Written Representation to the Examining Authority (ExA) regarding the Environmental Statement submitted by Tritax Symmetry (Hinckley) Ltd in respect of their proposed Hinckley National Rail Freight Interchange and with particular reference to Chapter 10: Noise and vibration

This Written Representation is with particular reference to Chapter 10: Noise and vibration, reference: 6.1.10, revision 07 [APP-119] and its associated documents.

NMP4 - Time History Graph

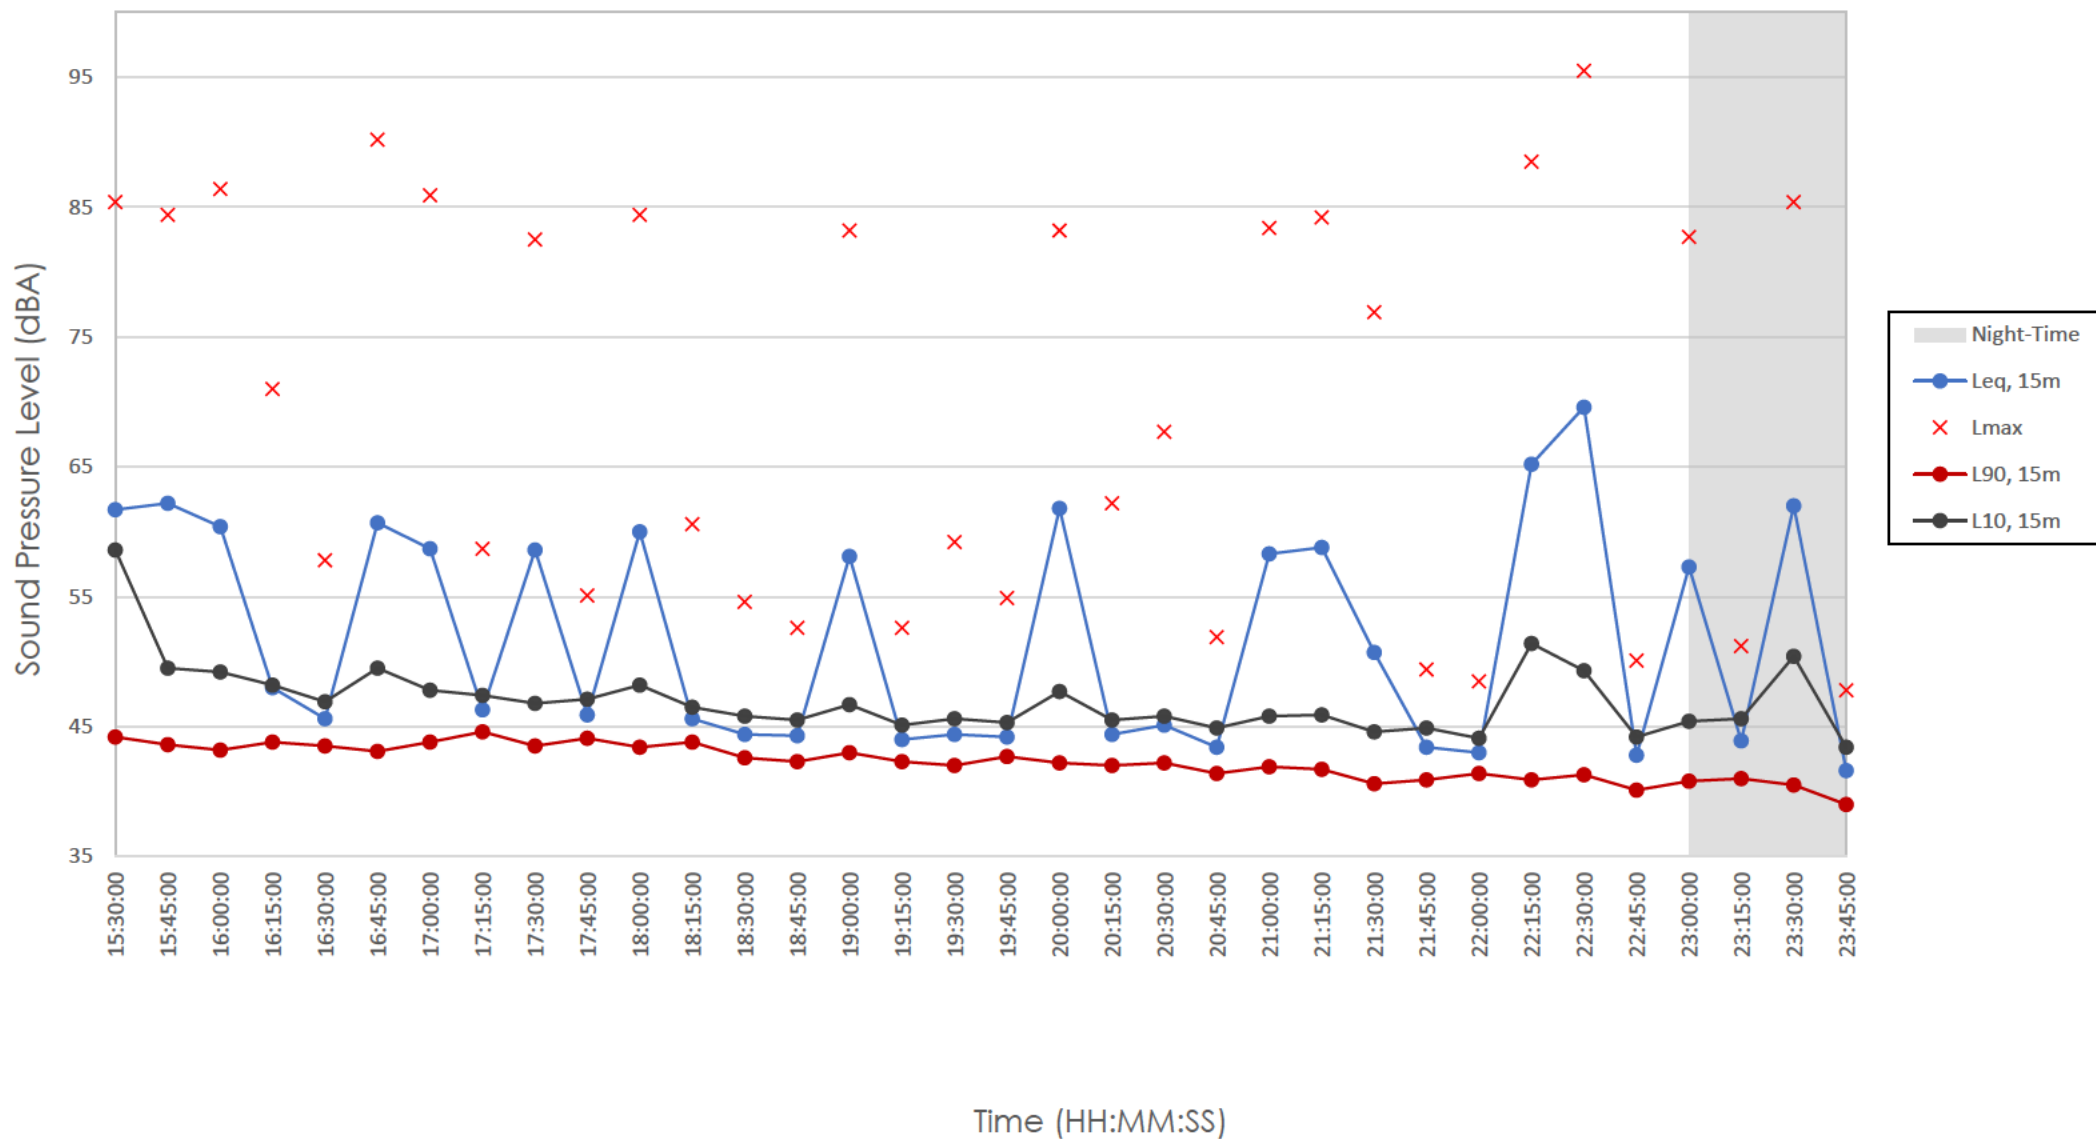
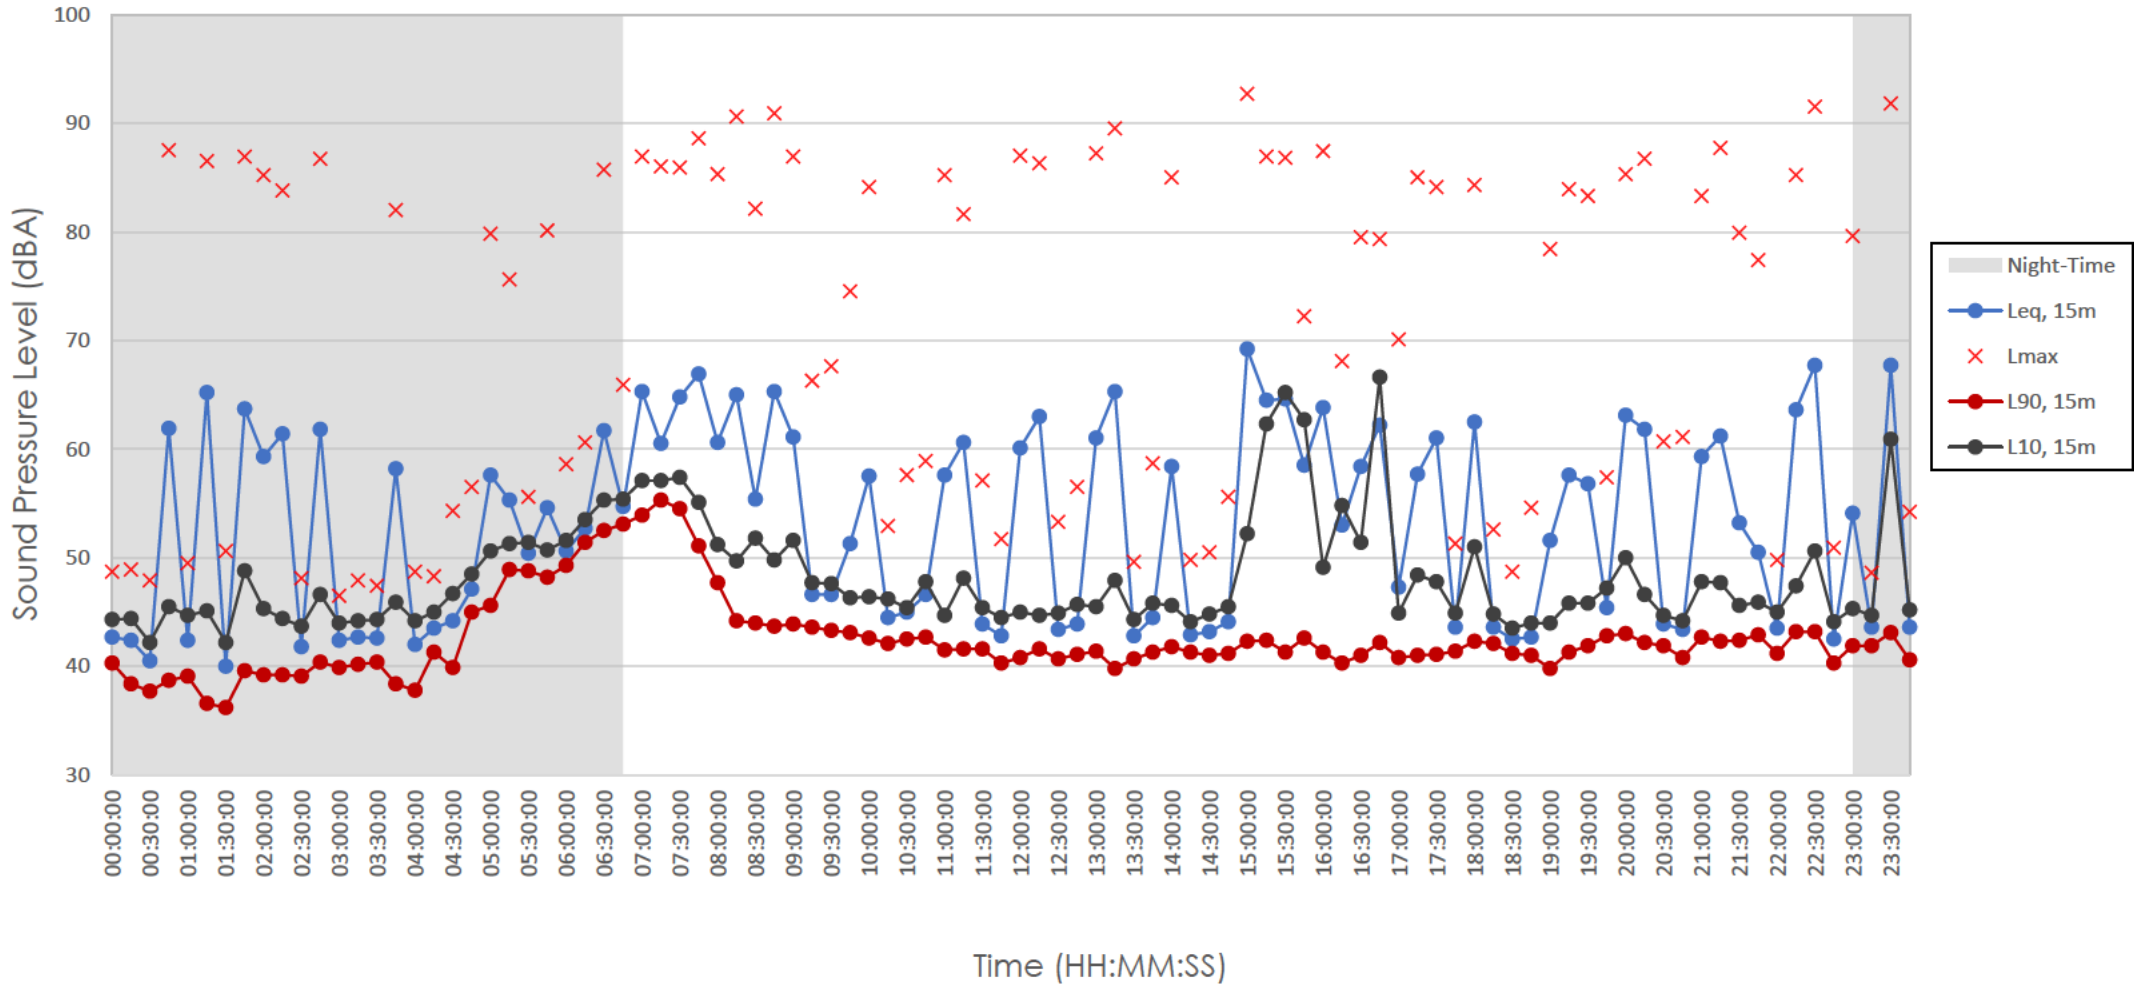
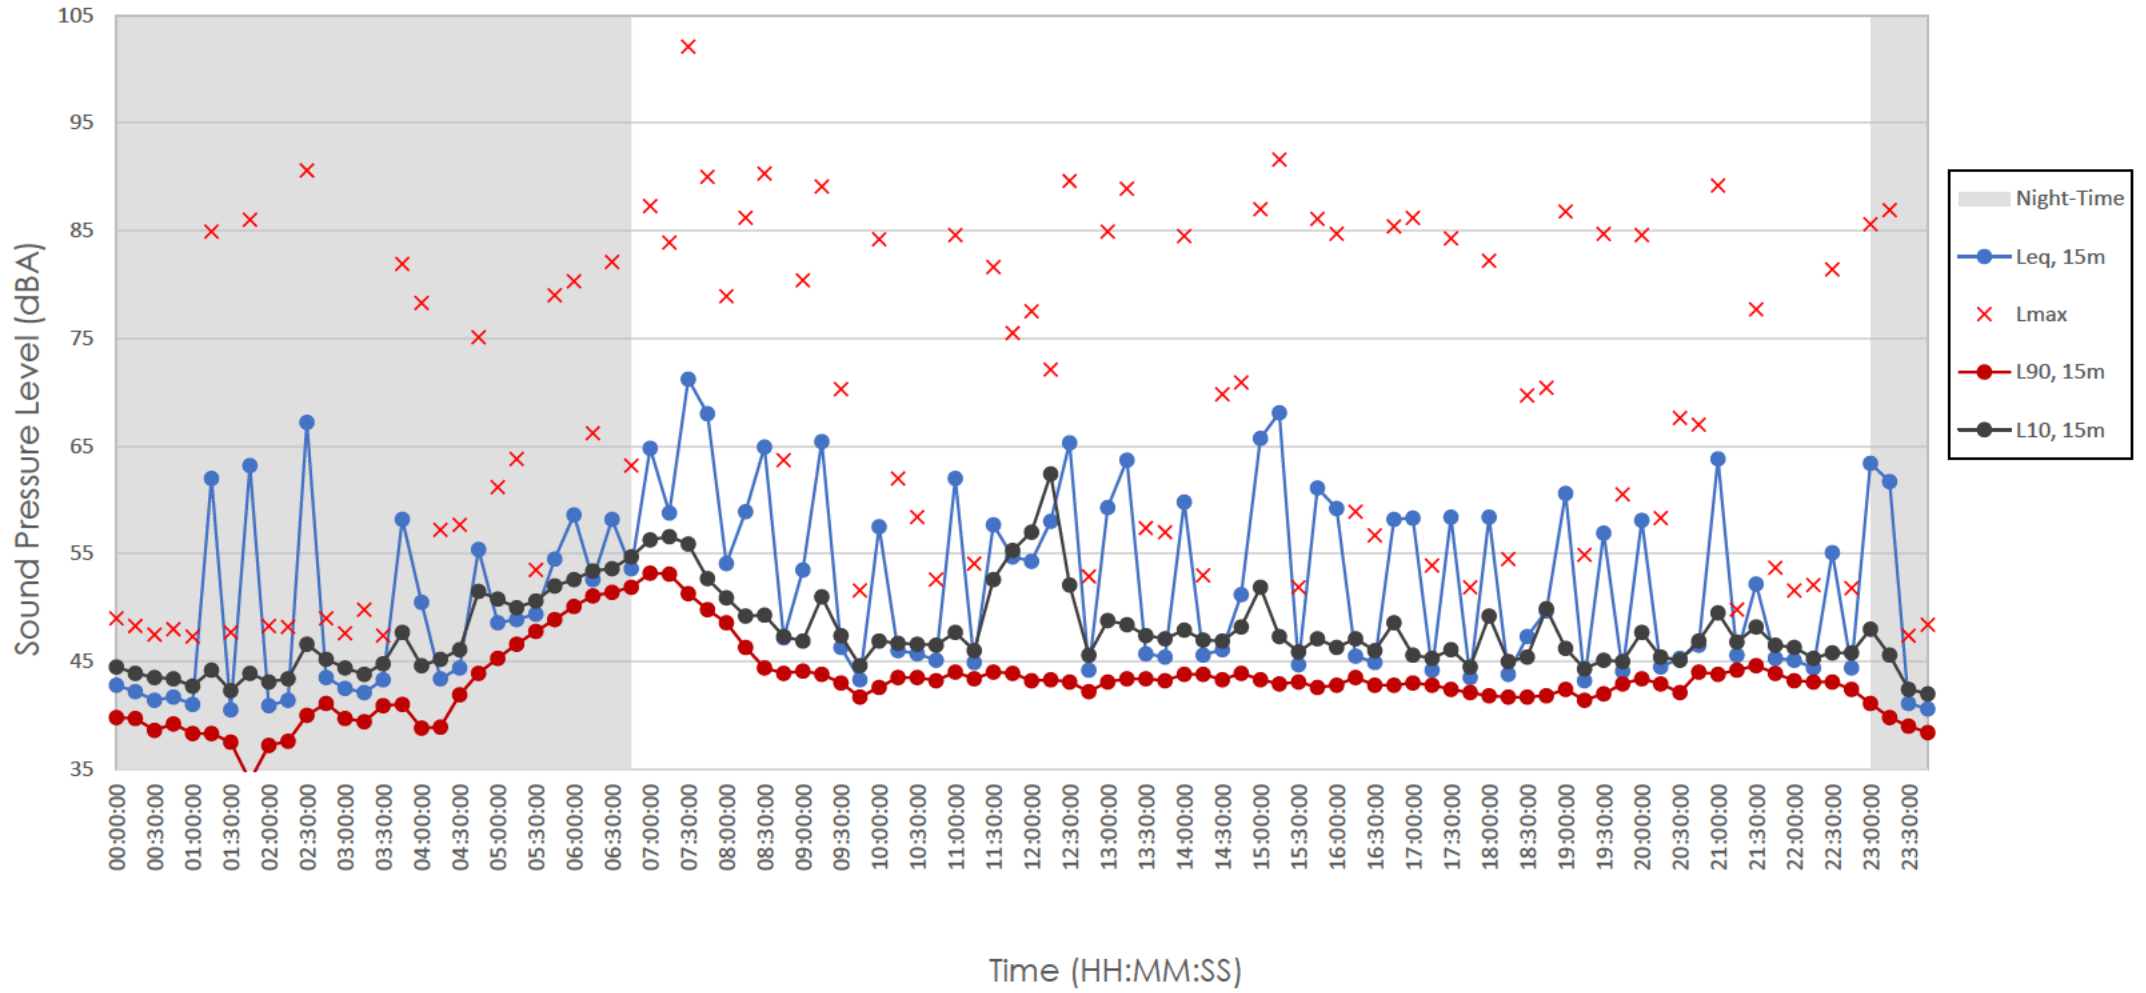
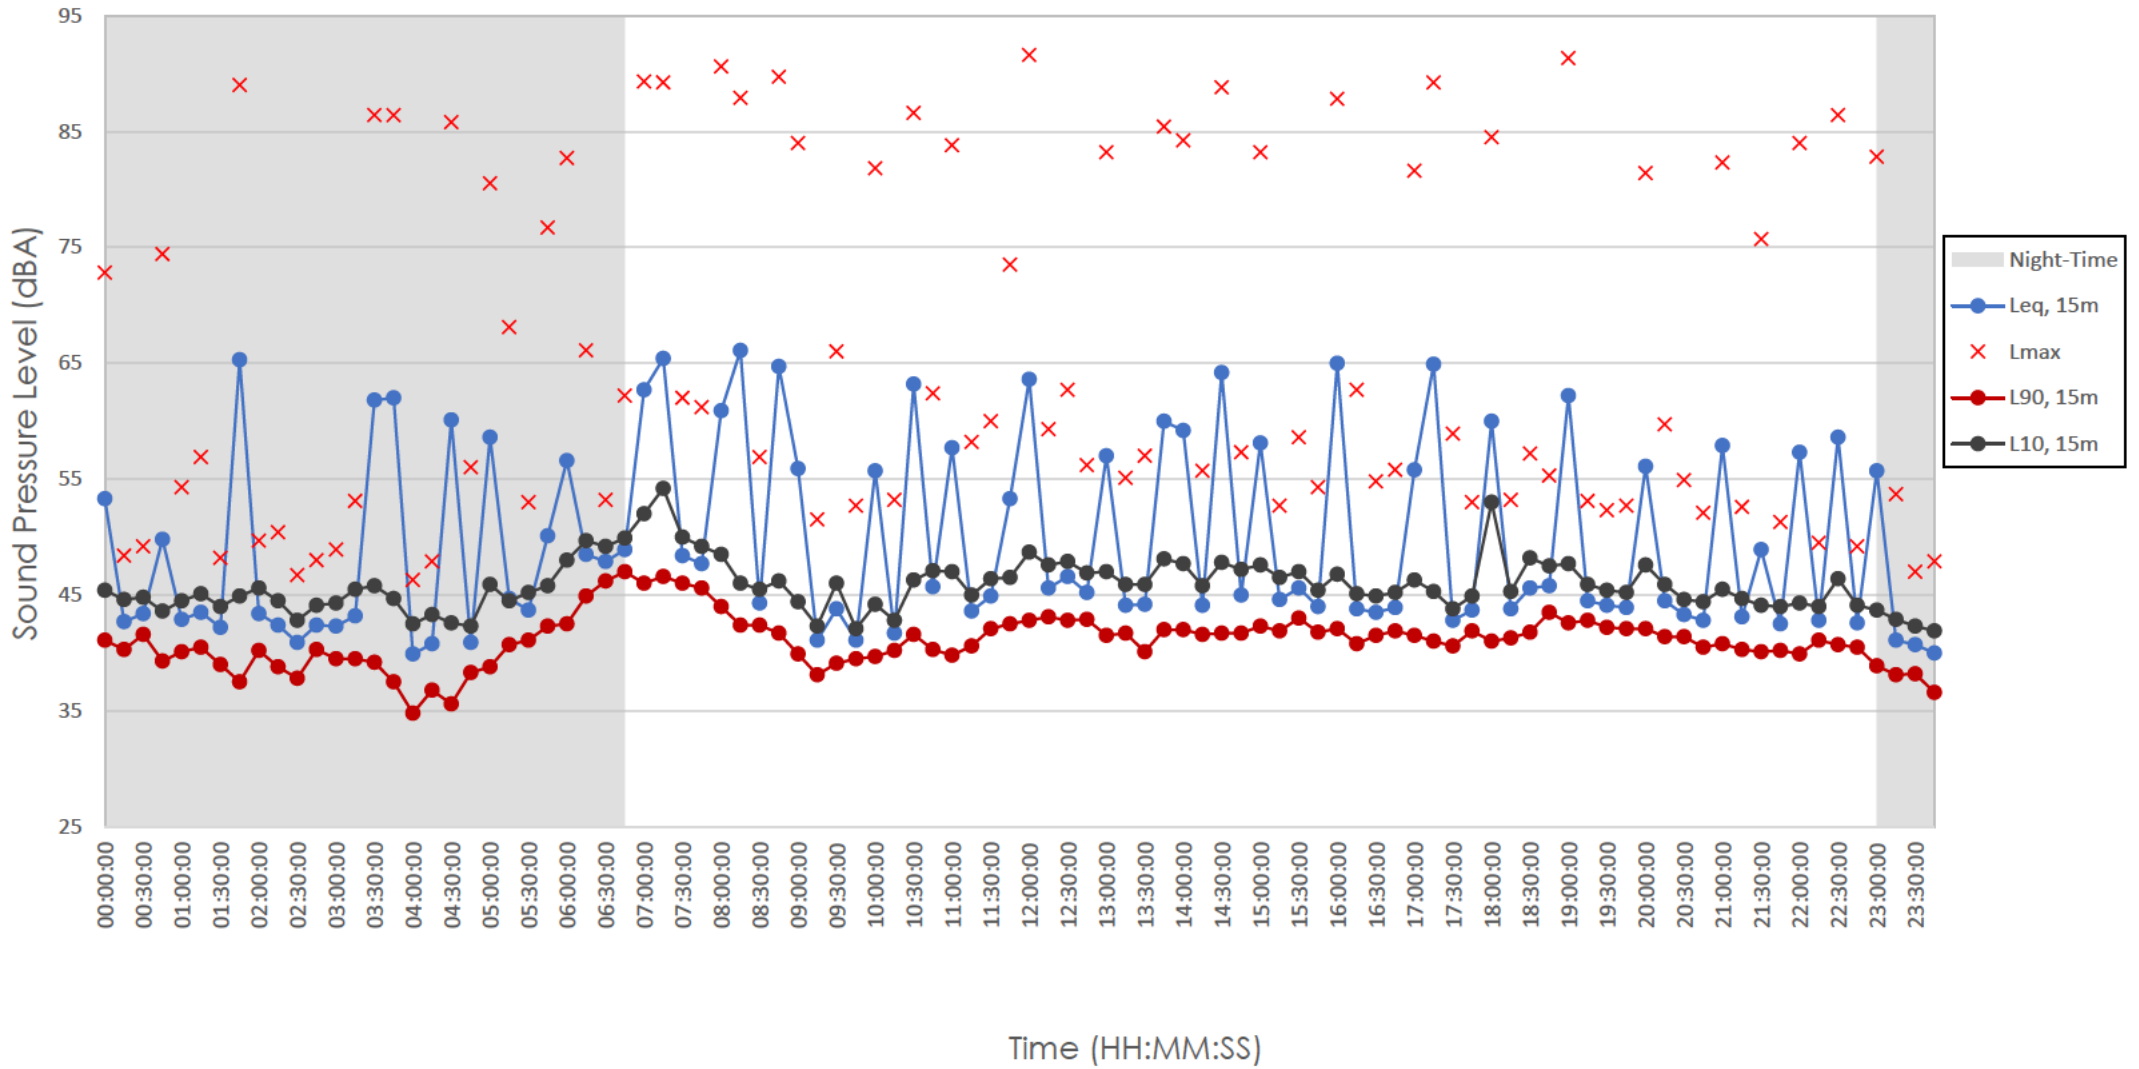
This means, for example, that the sound levels L_{Aeq} measured at noise monitoring position NMP4 have been taken and directly imposed upon all of the Noise Sensitive Receptors NSR1, NSR2, NSR3, NSR4, NSR5, NSR6, NSR7, NSR8, NSR24, NSR25 and NSR26.

This is wrong, and is a flagrant, fundamental and extremely grave failing in Tritax’s Noise and vibration report.

Because in conditions where the Ambient sound is strongly dependent upon a Specific Sound Source, both the Specific Sound and the Ambient Sound are strongly dependent upon the distance from that Specific Sound Source.

Were it not for the fact that this appears in an Environmental Study for a Strategic Rail Freight Interchange, Tritax’s approach here would be slightly comic. Because it means, for example, that Tritax believe that each one of the eleven NSRs mentioned above all actually experience the same ambient sound level, L_{Aeq} , as the Noise Monitoring Position NMP4 that Tritax placed close by the side of the railway track! Even though some of those NSRs are located in excess of 400 metres away from the railway track!
